MEMORANDUM

DATE: September 25, 2012

SUBJECT: 21 Quiet Lane

Misc Plot Plan

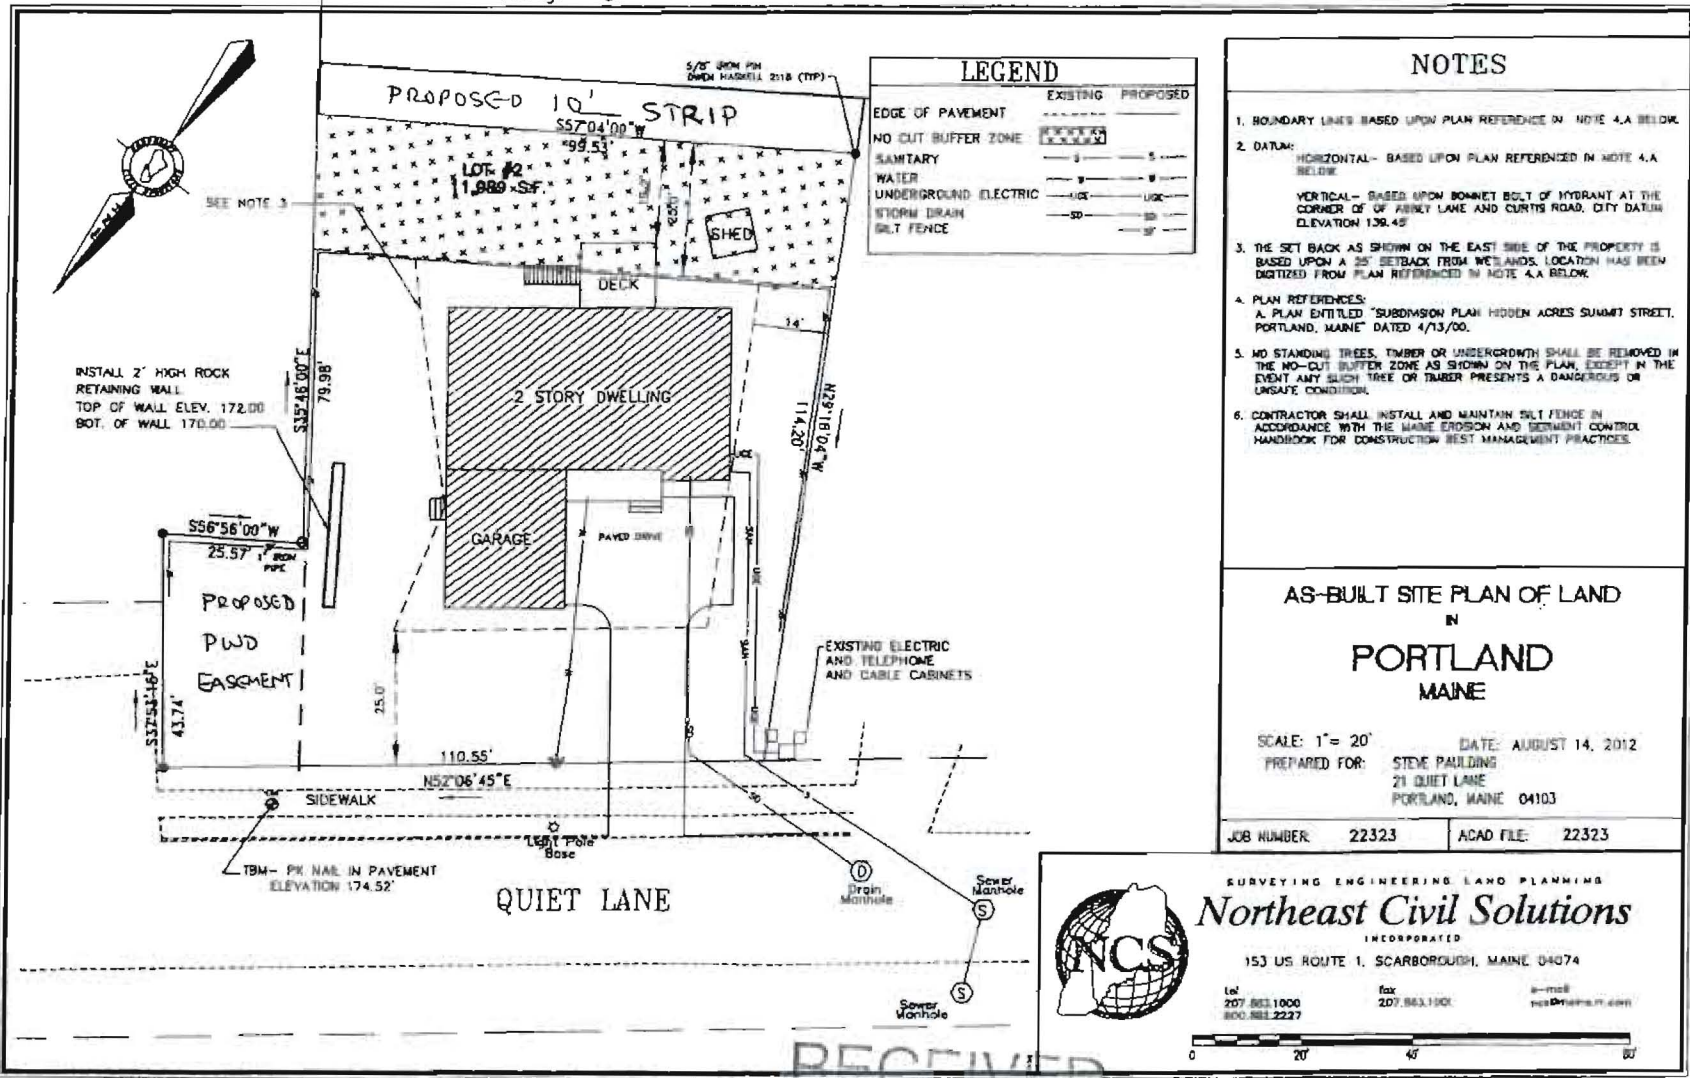
Excerpts of the subdivision plan and the site plan are attached, which include Lot #2 (21 Quiet Lane). The wetland extends along the two side property boundaries, but is not shown within the no-cut area along the rear line. The grading of the site was to occur outside of the no-cut buffer and drainage easements are shown in other areas of the subdivision, but are not shown on this lot.

Based upon a review of the file, it appears that the property owner will need to seek an amendment to the subdivision plat from the Planning Board for the deck that extends into the no cut area; however it appears that the deck does not impact a wetland. The existing survey for 21 Quiet Lane shows a shed located in the no-cut area, which should be relocated out of the no-cut buffer.
